13 January 2017

Deana Burn  
Department of Planning and Environment  
BY EMAIL: [deana.burn@planning.nsw.gov.au](mailto:deana.burn@planning.nsw.gov.au)

**MP06\_0228 MOD 12 – SHOALHAVEN STARCHES FACILITY, BOLONG ROAD, BOMADERRY**

TITLE: MODIFICATION TO SHOALHAVEN STARCHES EXPANSION PROJECT.  
PROPOSED BEVERAGE GRADE ETHANOL PLANT.  
PLAN VIEW OF NEW WORKS.

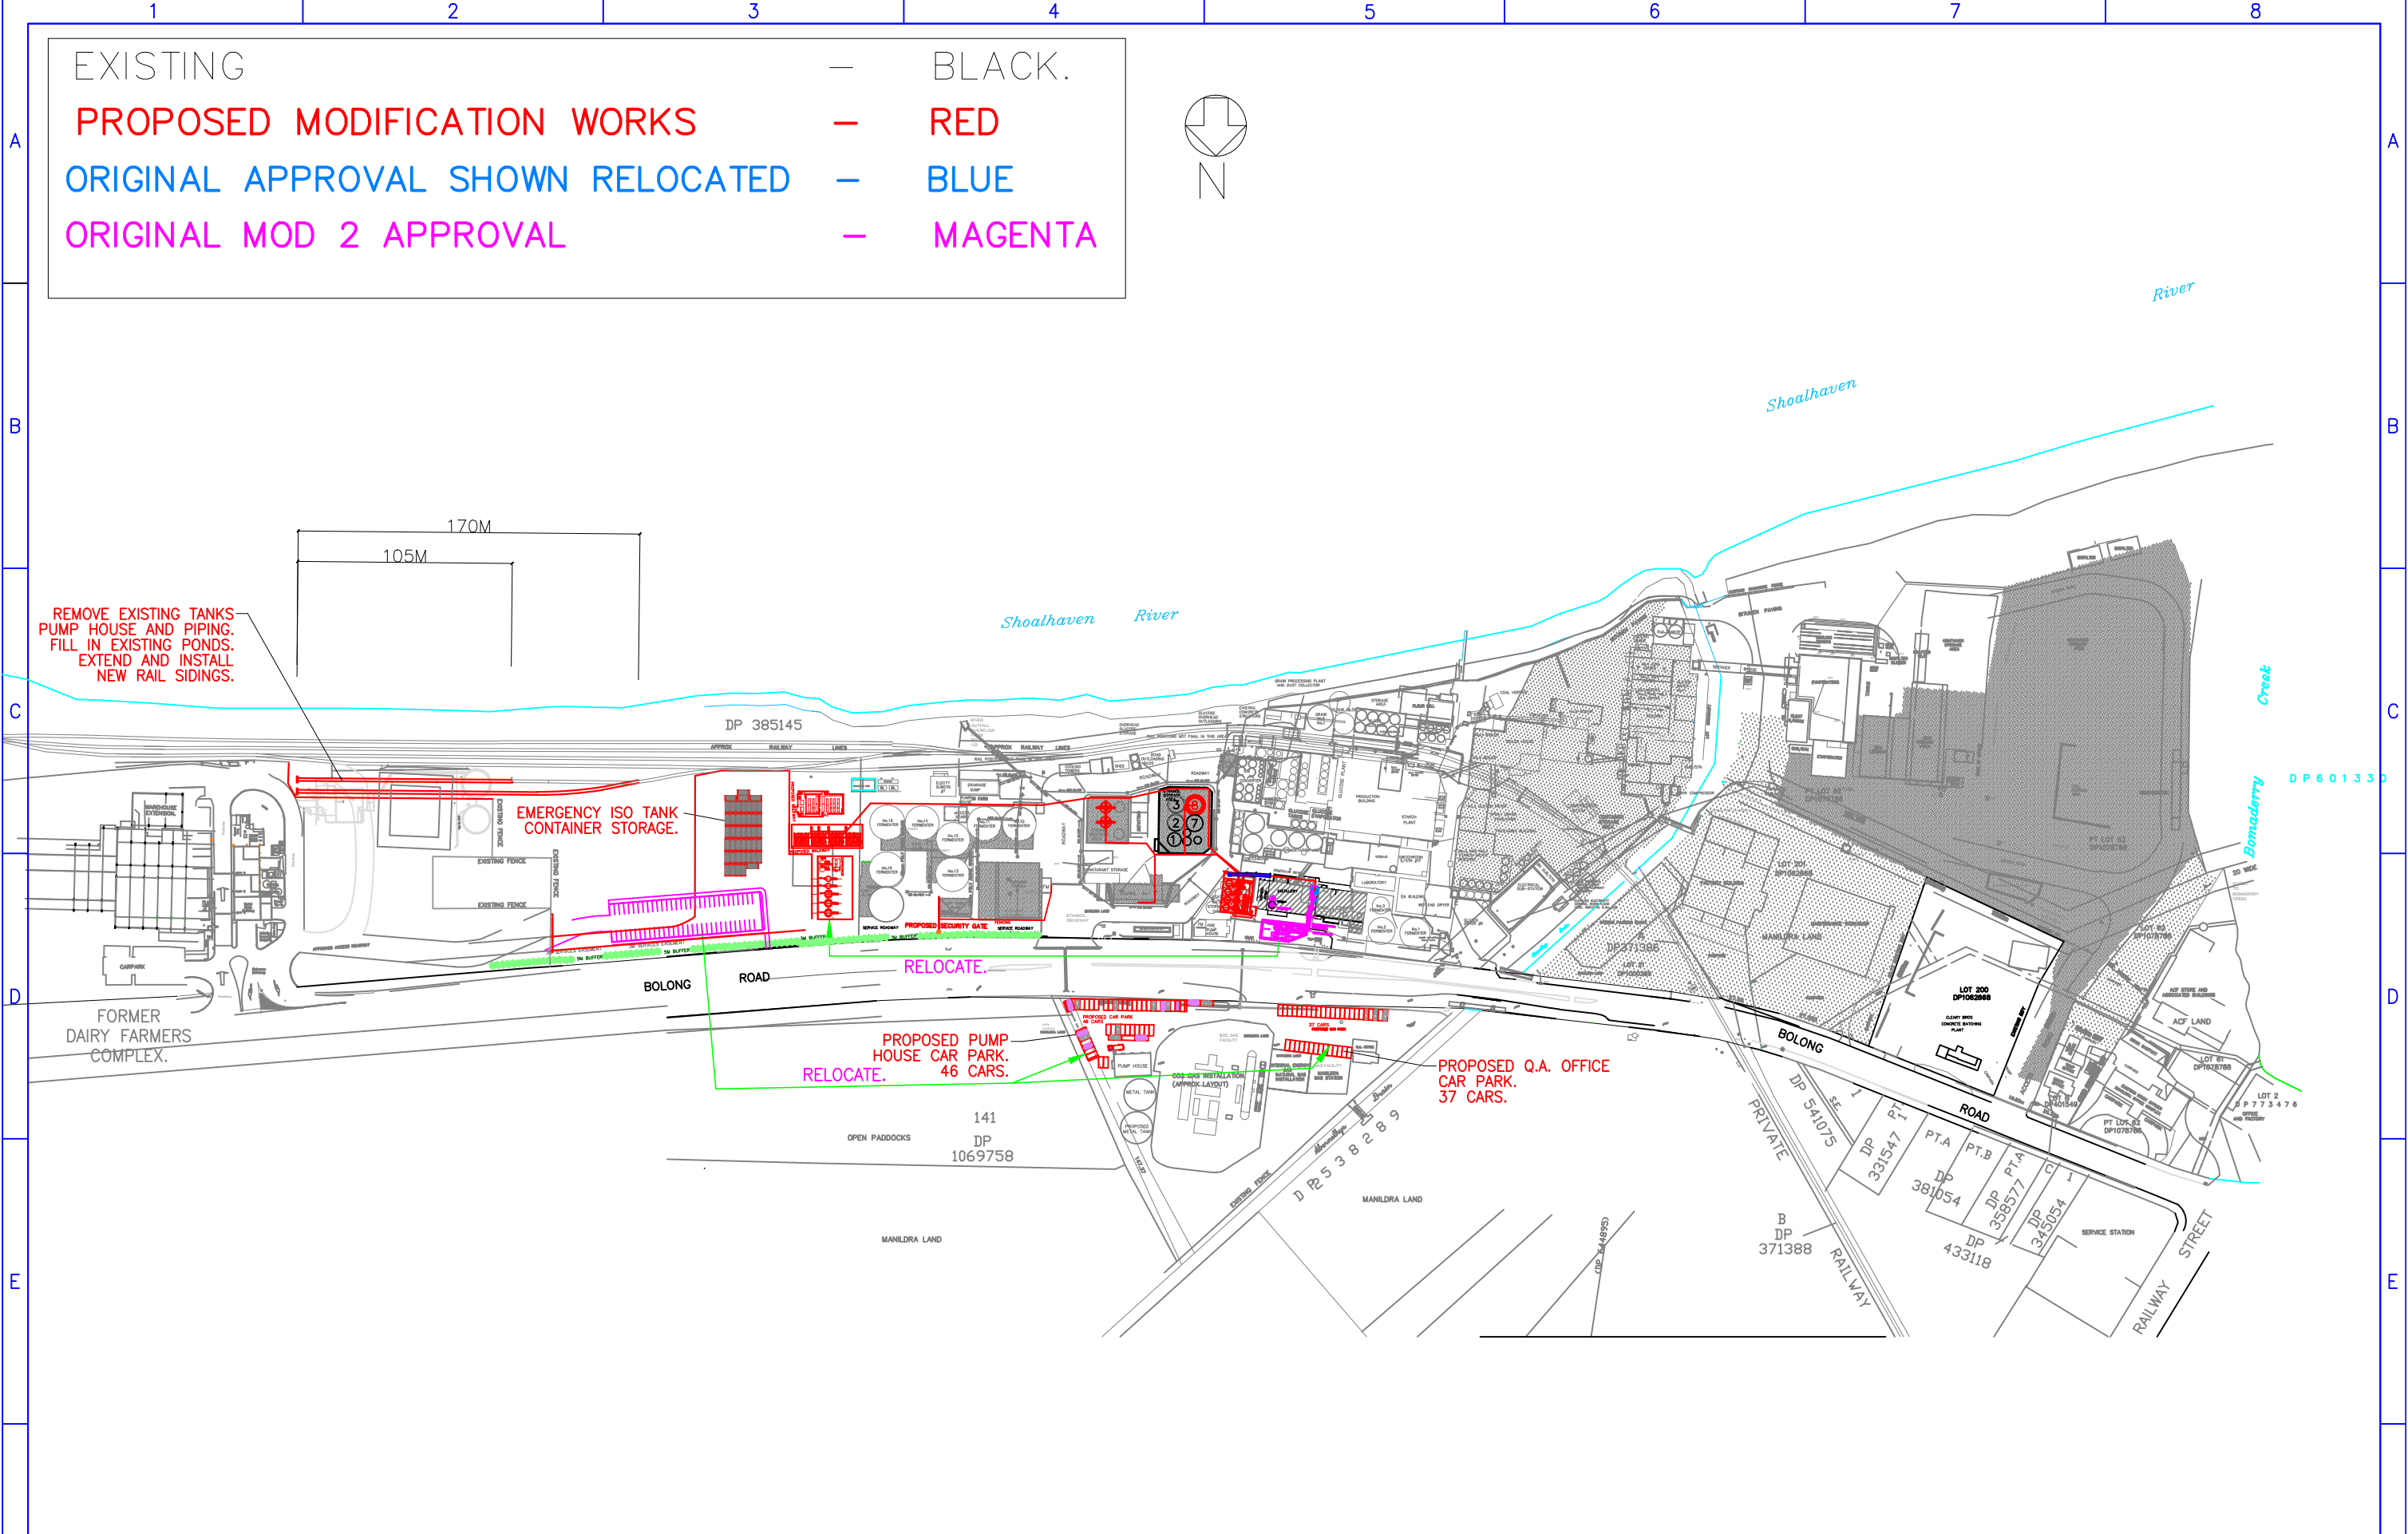
- Overall Car Parking Plan: RMS has been unable to locate details on all existing car parking provided within the site (i.e. total car parking provision including both temporary and permanent car spaces). As such, it would be beneficial to obtain a plan from the applicant that clearly shows all approved and proposed car parking to service the development. It is noted that DPE has previously detailed that a total of 349 car spaces provided within the development site (assessment report for Mod 3). It is however currently unclear, given the number of modifications, how many car spaces are currently provided within the development site and there location, noting that some of the previously proposed car parking has been modified due to changes in building footprints and is temporary in nature.

**TITLE:**  
MODIFICATION TO SHOALHAVEN STARCHES  
EXPANSION PROJECT.  
PROPOSED BEVERAGE GRADE ETHANOL PLANT.  
PLAN VIEW OF TRAFFIC MANAGEMENT & NEW RAIL SIDING.

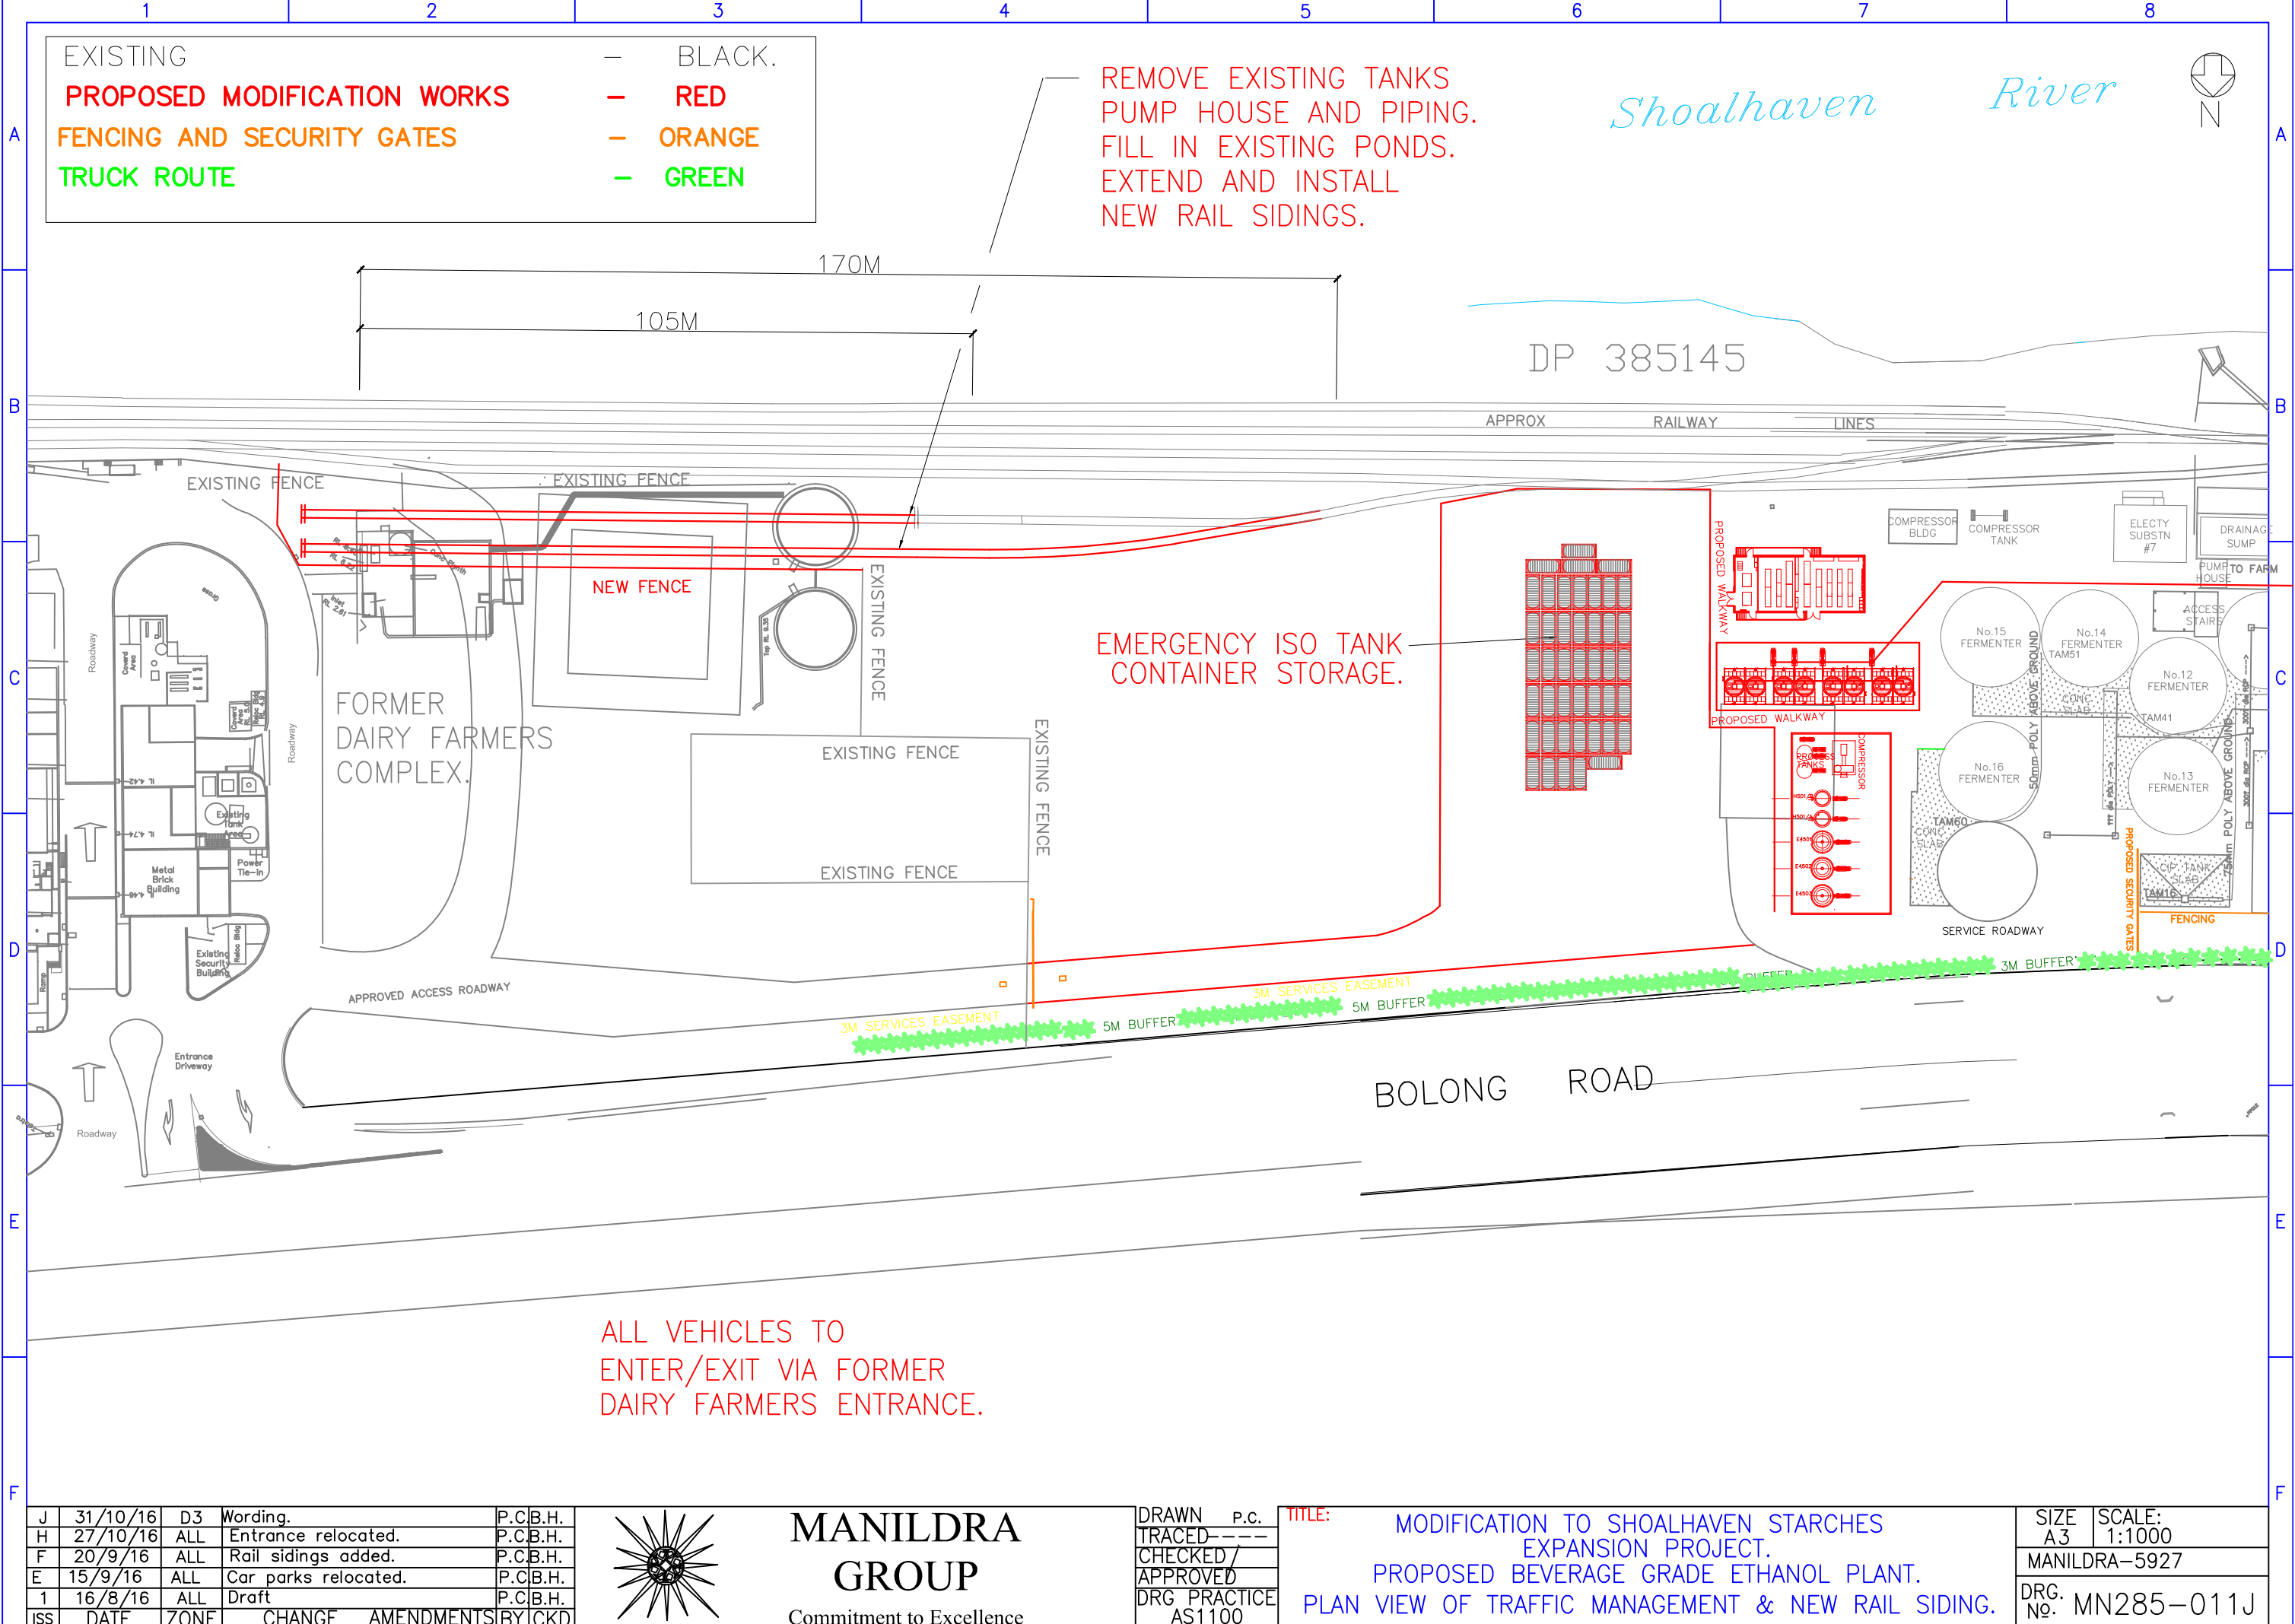
- Proposed Car Parking Layout: RMS notes that the car parking layout plans submitted for Mod 12 are general in nature and contain no details on car space dimensions, aisle widths, etc. While the supporting written information outlines that this car parking will be constructed to Australian Standards and will be sealed, a site visit has indicated that:

- The number of spaces as shown on the submitted plans may not fit within the proposed car parking area. Specifically, the western car parking area which has a frontage of approximately 54m (frontage of the car spaces as shown on the plans) and provides 23 car spaces along the Bolong Road frontage will result in car spaces that do not comply with Australian Standards;
- The eastern car parking area contains a fire pump house which in the event of a fire will require access by a fire truck. Confirmation should be obtained that the proposed design will allow a fire truck to manoeuvre into and out of the site without any obstructions; and
- Existing car parking areas visible from Bolong Road are currently constructed to a gravel standard.

DPE should ensure all required car parking can be physically provided on site so as to ensure cars are not forced to park within the adjoining road reserve area (i.e. Bolong Road). A plan should be obtained from the applicant that demonstrates that all car parking proposed under Mod 12 can be contained within the areas noted on the submitted plans and should include dimensions of aisles, access points, car spaces, etc.

- Pedestrian Access: RMS notes that formal pedestrian access (i.e. concrete footpath) is not currently provided along the northern side of Bolong Road in the vicinity of the proposed car parking areas. DPE should ensure formal pedestrian access is provided.
- Recommended Conditions: The DPE letter dated 13 December 2016 in part sought advice on recommended conditions of consent. RMS has been unable to locate any details/information on the DPE website relating to conditions of consent and as such no comments on this aspect have been provided at this time.
